From: Amanda Scholes on behalf of Planning.Responses
Sent: 02 March 2018 10:14
To: Planning Scanning
Subject: FW: Y/91/17/OUT & Y/92/17/OUT
Attachments: RE: Draft: RE: #4269 Planning Consultation on: Y/92/17/OUT; 20180301 HEPR - Y_91_17_OUT_Land at Bilsham Road.pdf; 20180301 HEPR - Y_92_17_OUT_Land east of Drove Lane.pdf; PROPOSED EXTENSION TO A27 YAPTON LANE RIGHT TURN.PDF

Y/91/17/OUT; and

Y/92/17/OUT.

Highways England Planning Response (HEPR 16-01)

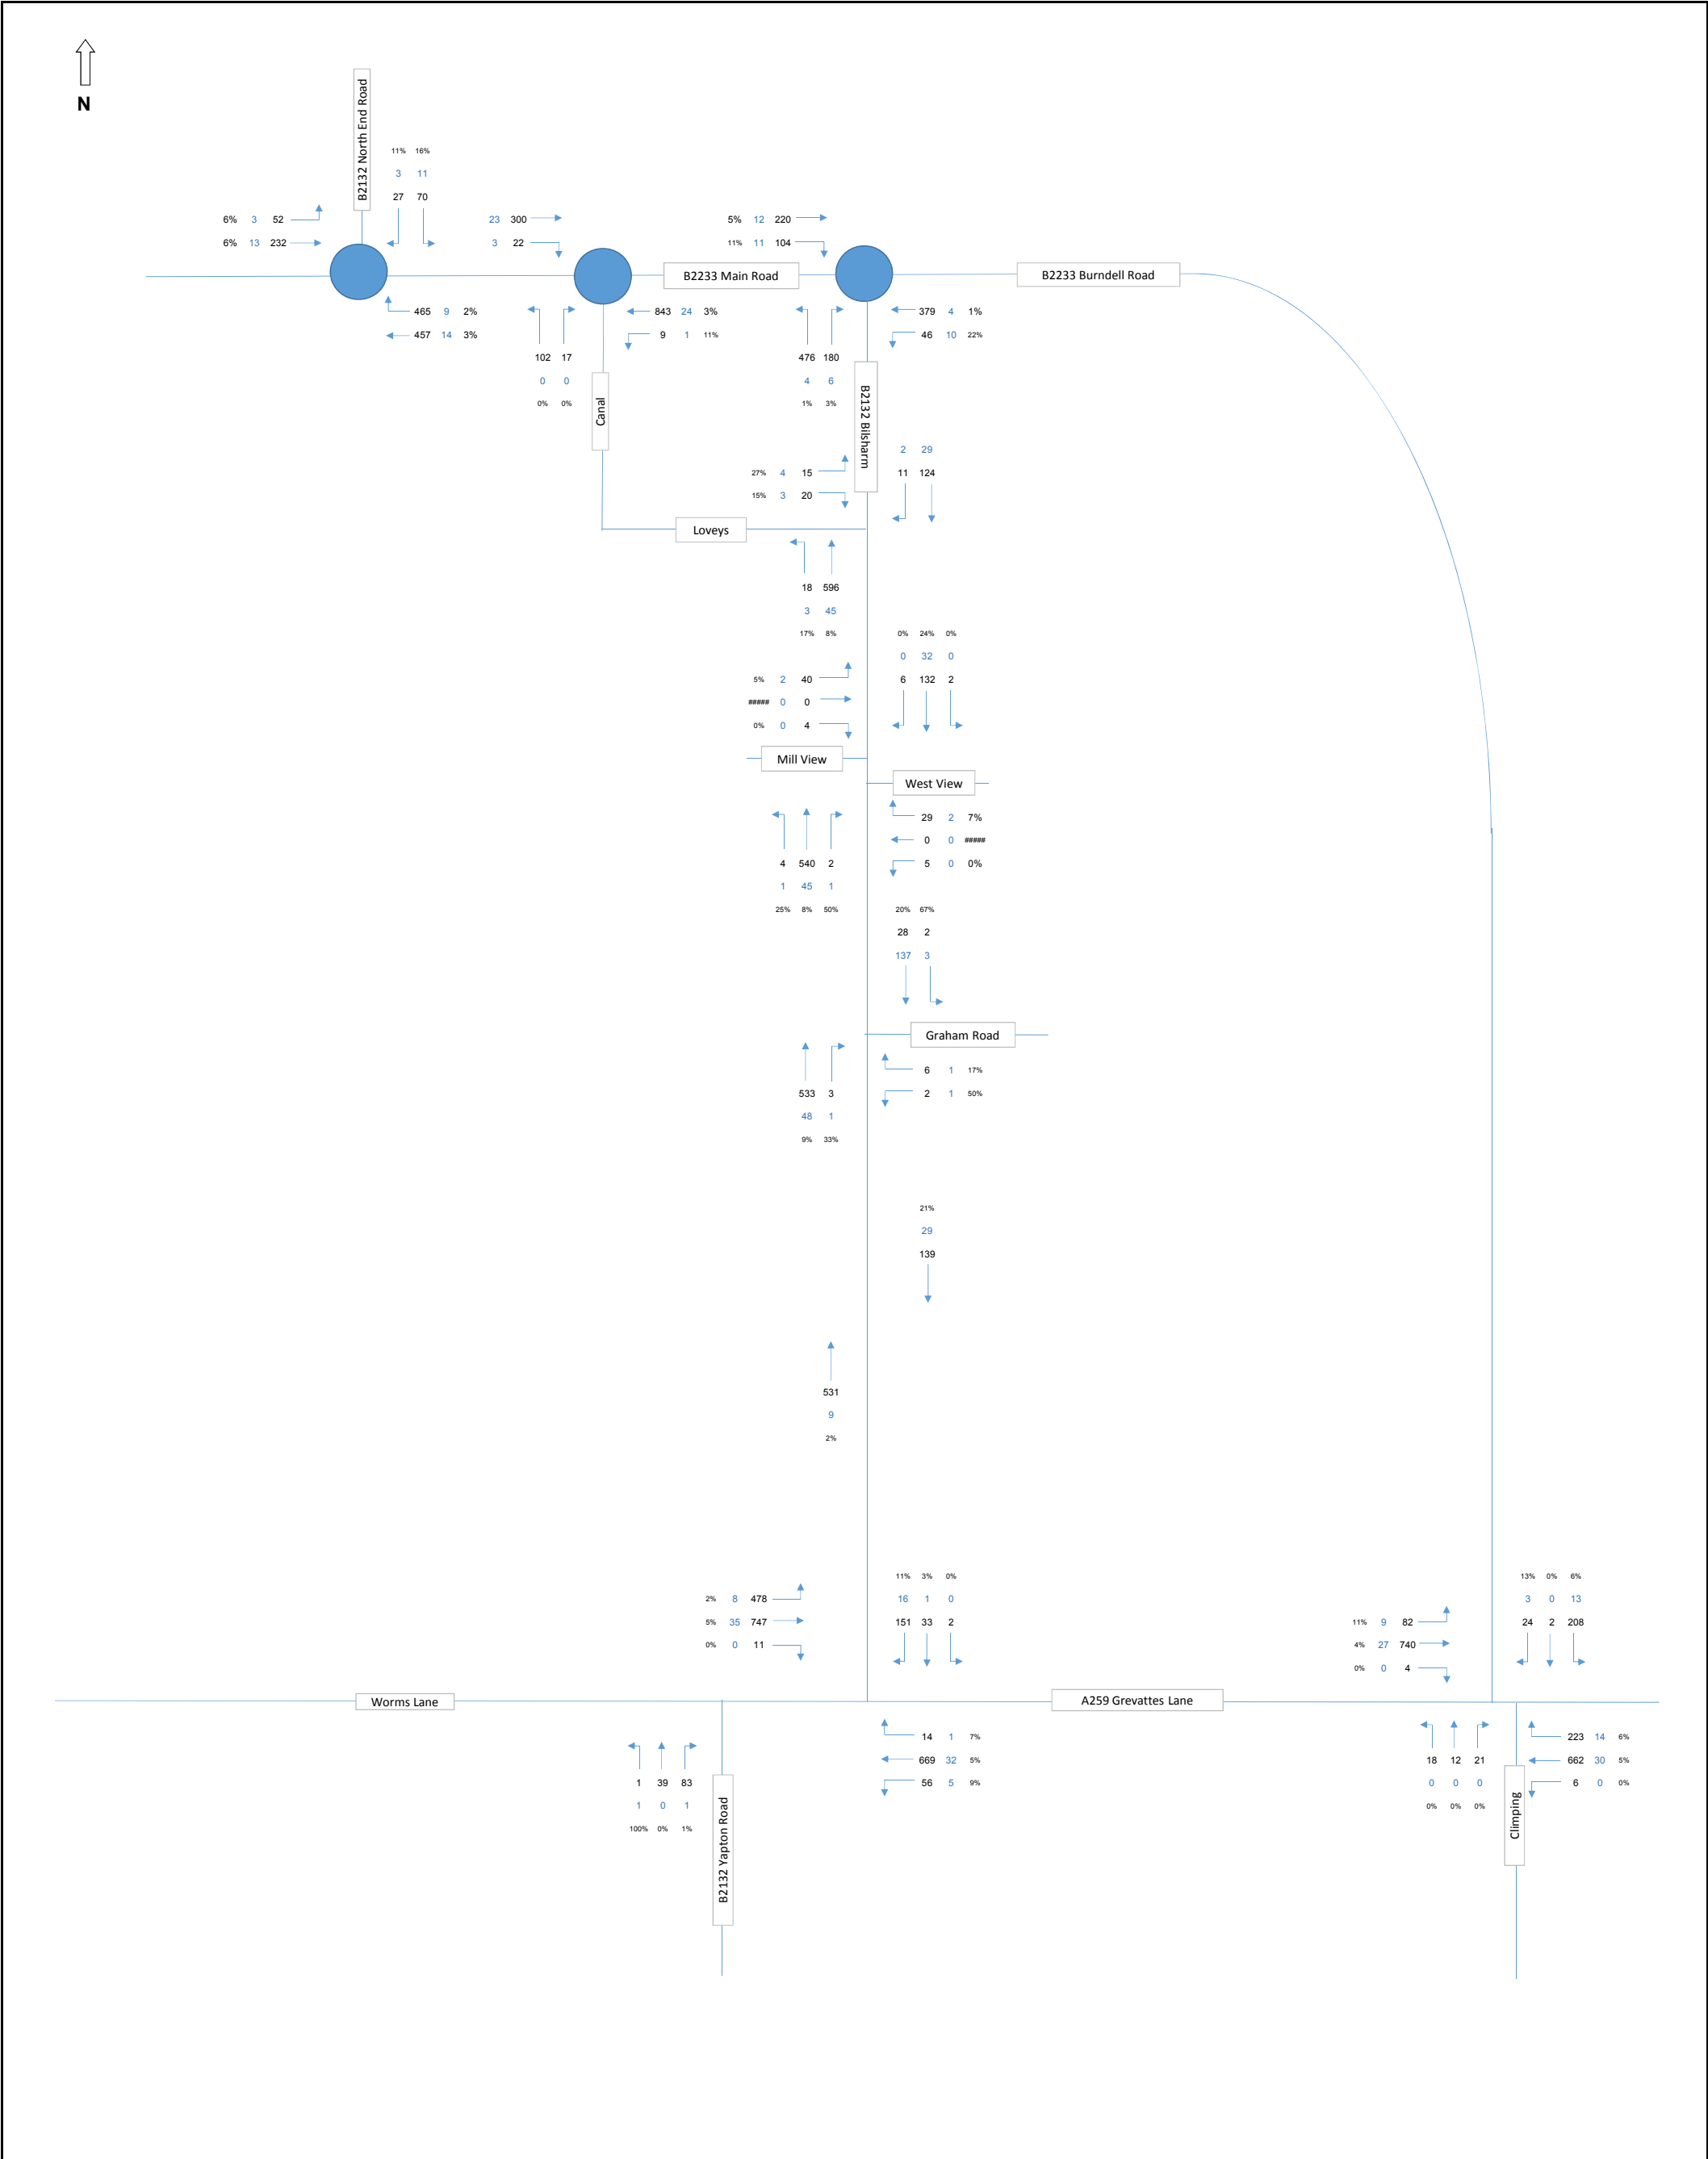
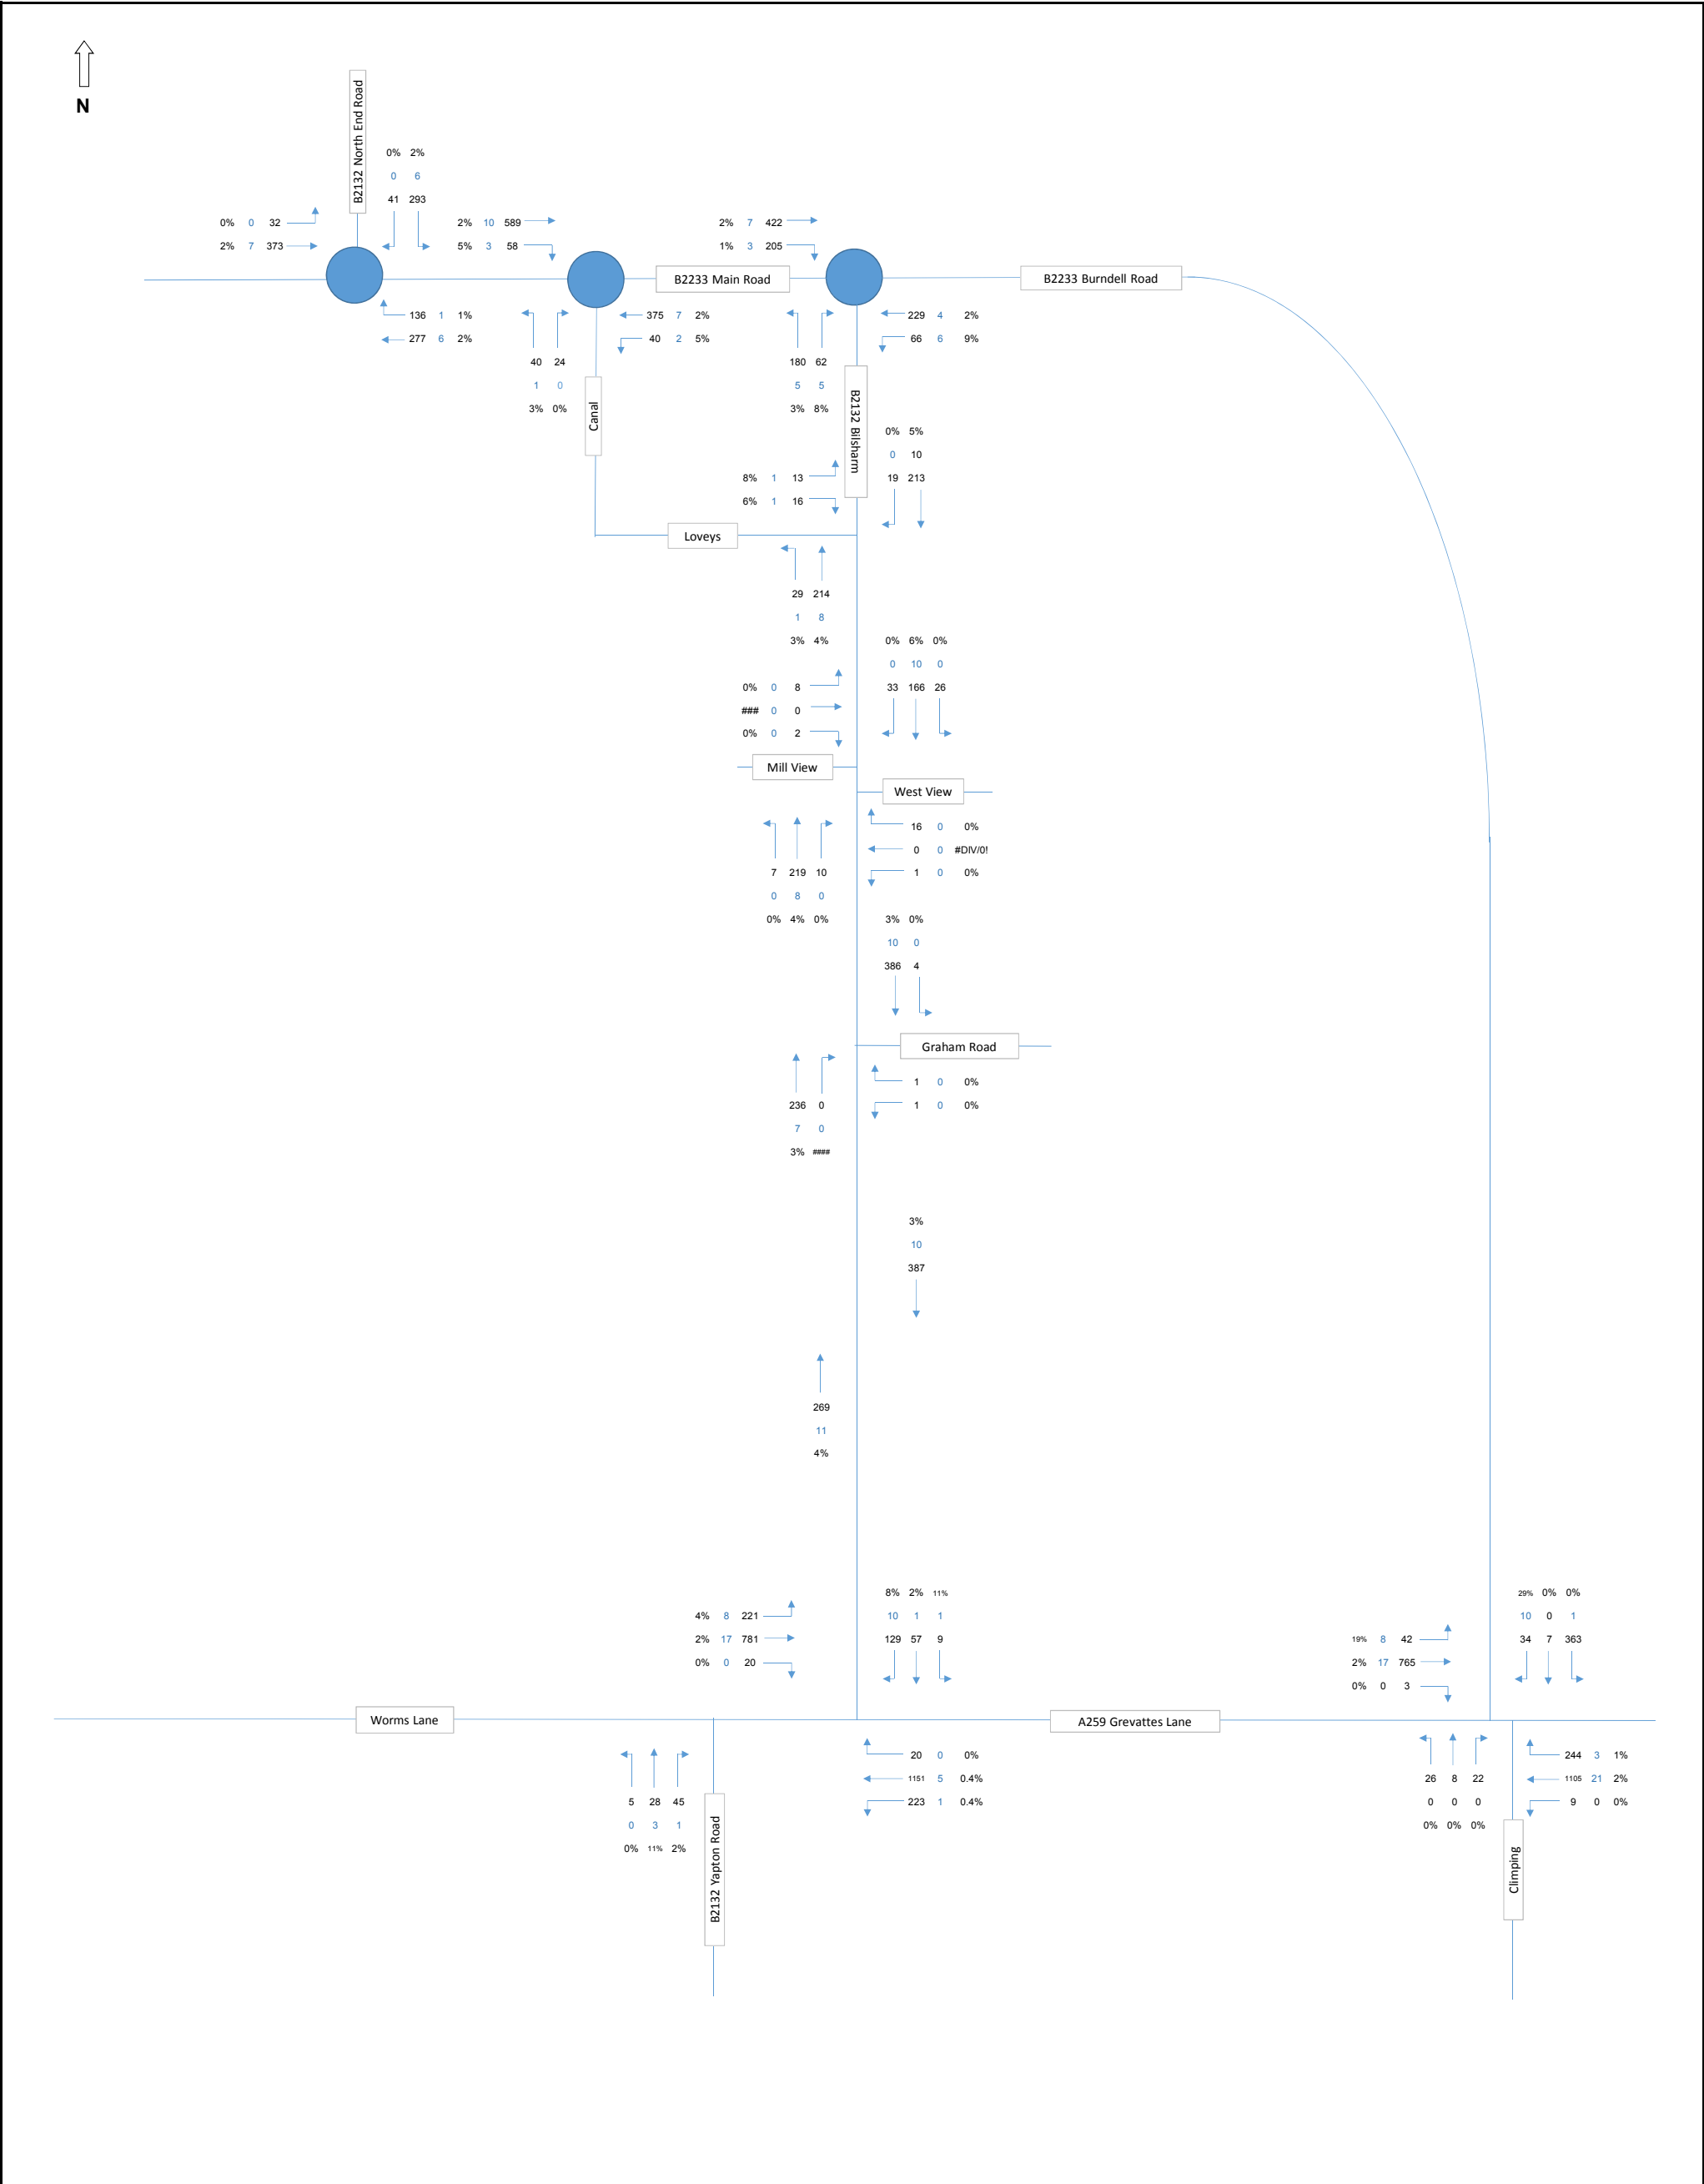
We note that there is no traffic flow diagram for development flows only in Appendix I and request that such a traffic flow diagram is provided to demonstrate the assignment of development traffic flows.
